DECISION DELEGATED TO DEVELOPMENT MANAGER

Application No: H13-0221-20 **Applicant:** Mr & Mrs C Wilson

Proposal: Two storey side extension and single storey rear extension replacing existing conservatory

Location: 16 Thorpe Avenue Moulton Chapel Spalding

AMENDED PROPOSED GROUND FLOOR 16 THORPE AVENUE, MOUTON CHAPEL,
SPALDING, PE12 0XN 1cm=500mm

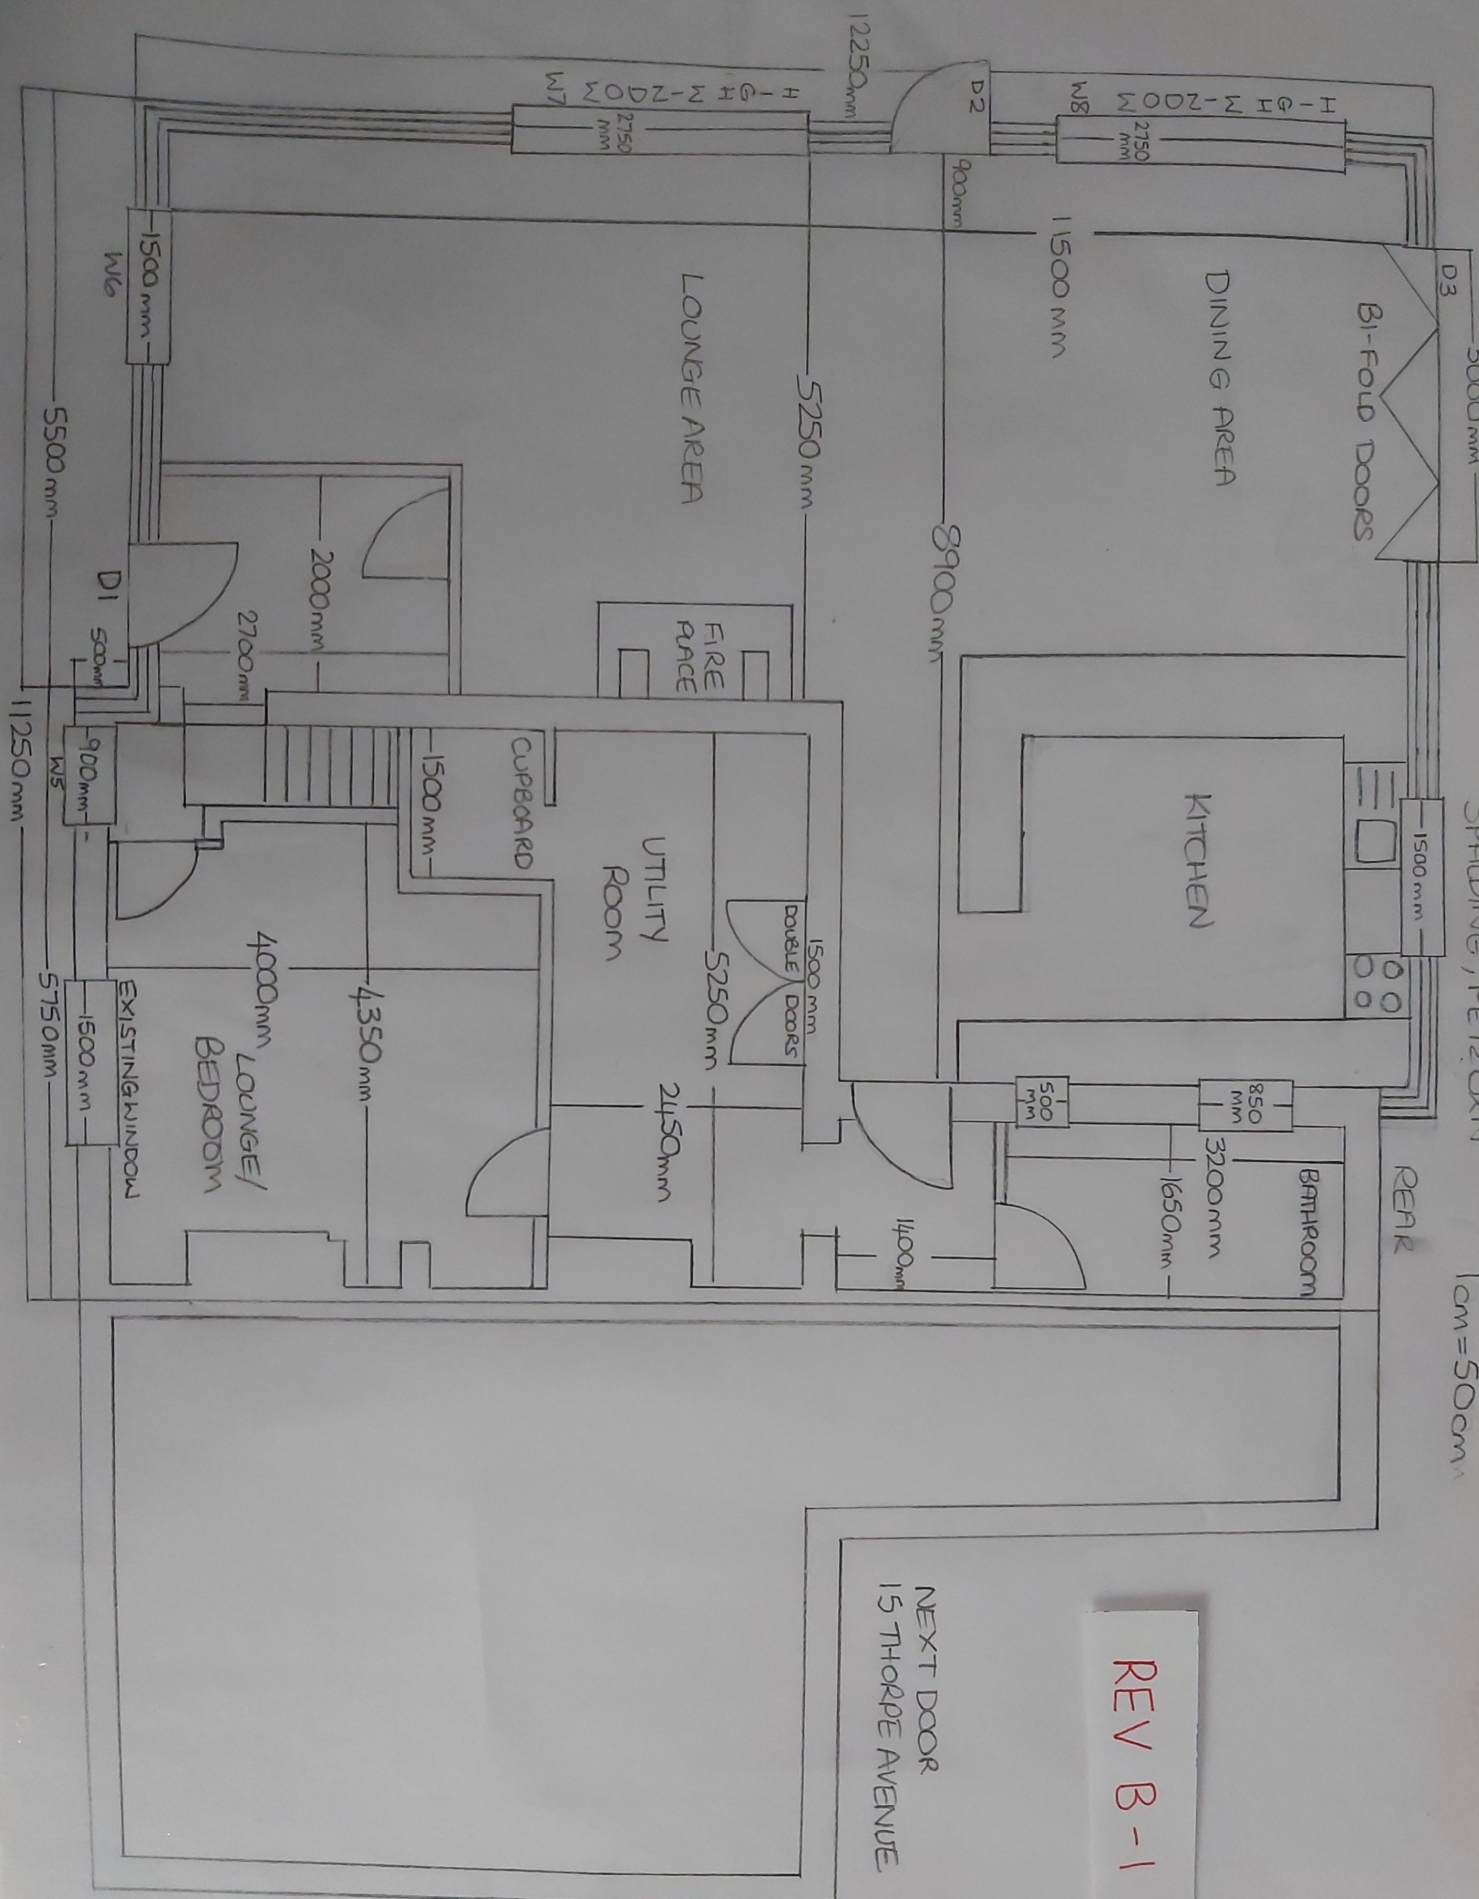
Internally, the development will increase floorspace to create large open space for lounge, dining room and kitchen. The existing front lounge will be converted into a bedroom. On the first floor level, there will be 4 no. double bedrooms, one of them ensuite. Internal works such as new walls, wall demolition, brick up and new openings will be carried out to vary the internal distribution for accommodating the proposed spaces. The proposed works will be in keeping with the residential

AMENDED-PROPOSED ELEVATIONS

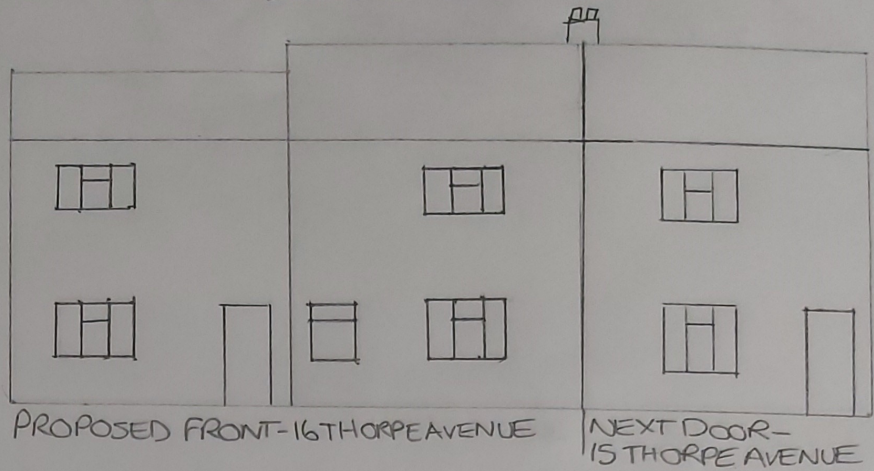
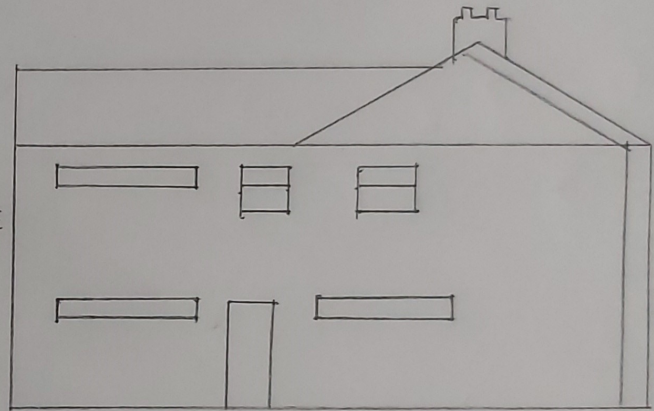
The extension will protrude 5.50 metres from the western side elevation and will extend nearly along the full depth of the host property. The eaves will be as much as those of the property. A gable pitched two-storey element will be formed on the rear elevation. In doing so, two gable pitches will be formed, one facing the west (No. 17) and one further facing the north (rear garden). The apex height perceived from both front and side elevations will slightly fall below the ridgeline of the dwellinghouse and the pitch height of the rear element will fairly lower than the main roof of the extension. From the original front wall, the proposed enlargement will be set back 500mm.

Two medium-scaled windows are proposed on the first-floor level of the side extension. Both lighten an ensuite and a bathroom, both non-habitable spaces, and would be obscure glazed. There is also one further window for the rear bedroom but it is of a high level slot type. In light of these features, no adverse overlooking will occur by the reason of the proposal.

AMENDED ②

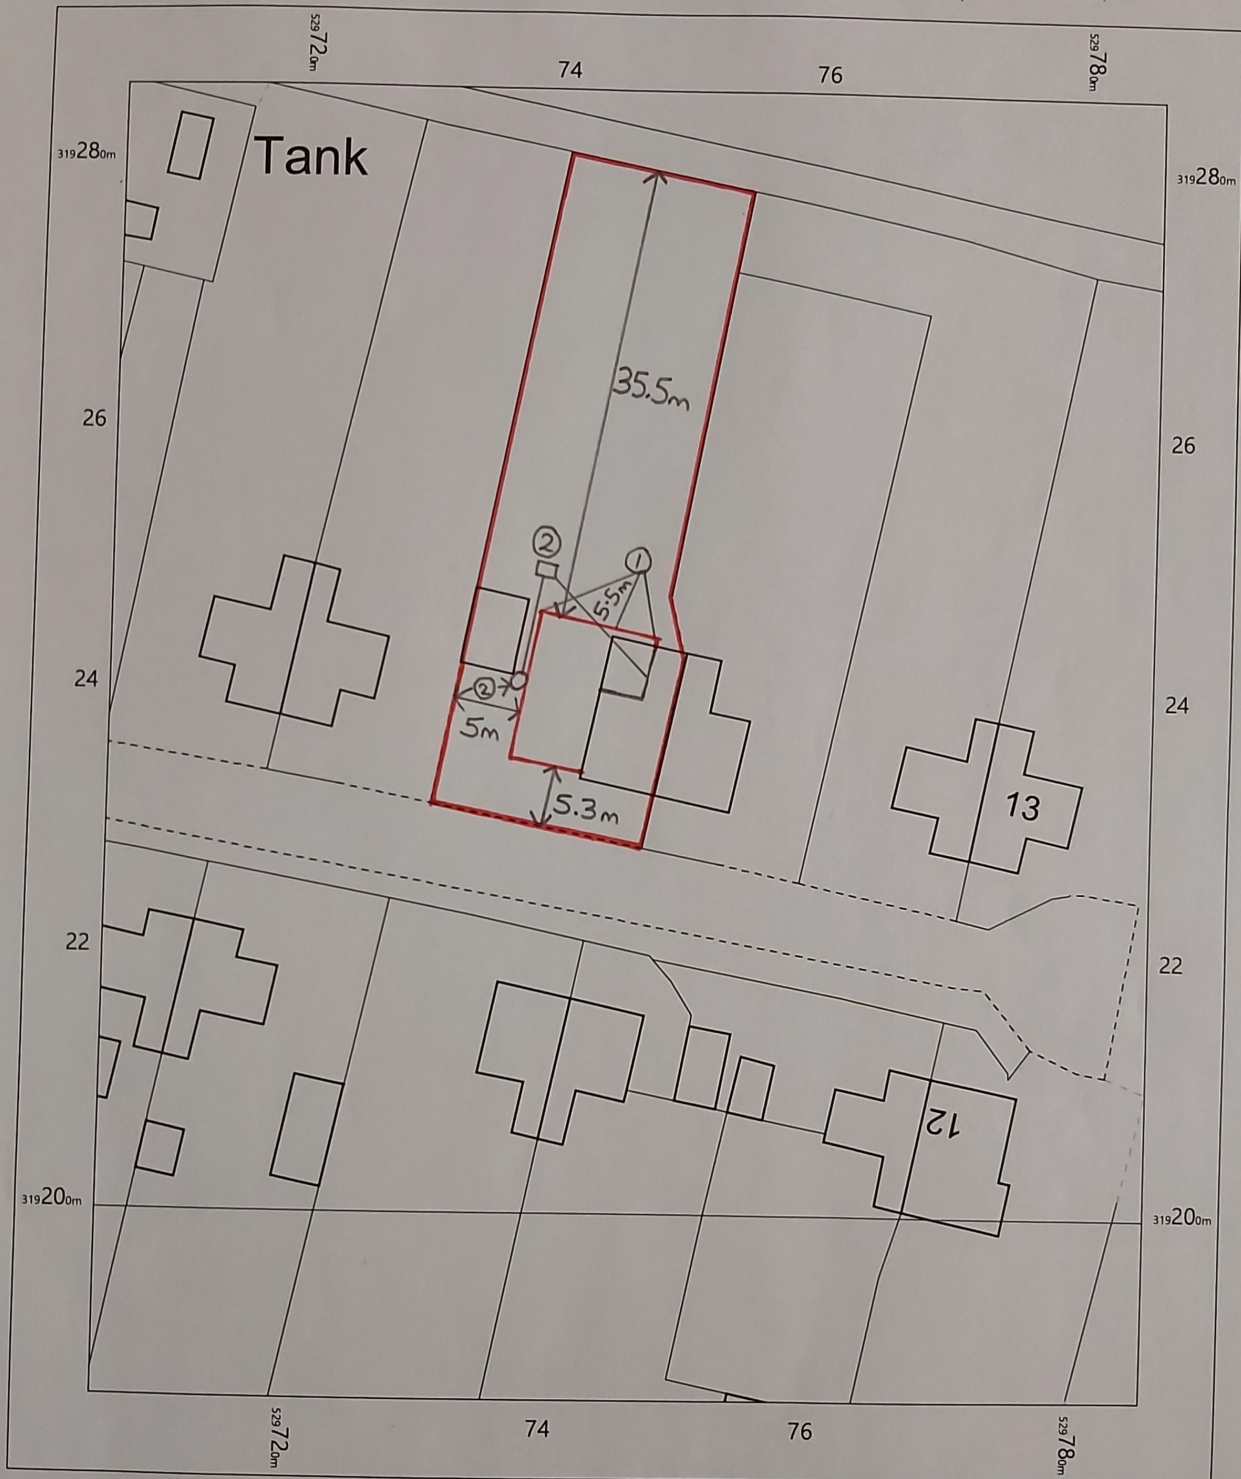
In spite of low flood risk probability, revised block plan has been submitted under case officer's request in order to incorporate the installation of soakaway in the rear garden to manage sustainably the surface water runoff coming from the proposed extension. In doing so, it is secured that the development is appropriately resilient to the effects of surface water flood risk and overall climate change following Policy 4 of SELLP. No evidence of poor soil permeability is known in the locality. In any case, the suitability of a soakaway will be tested and subsequently approved at a later stage by SHDC Building Control.
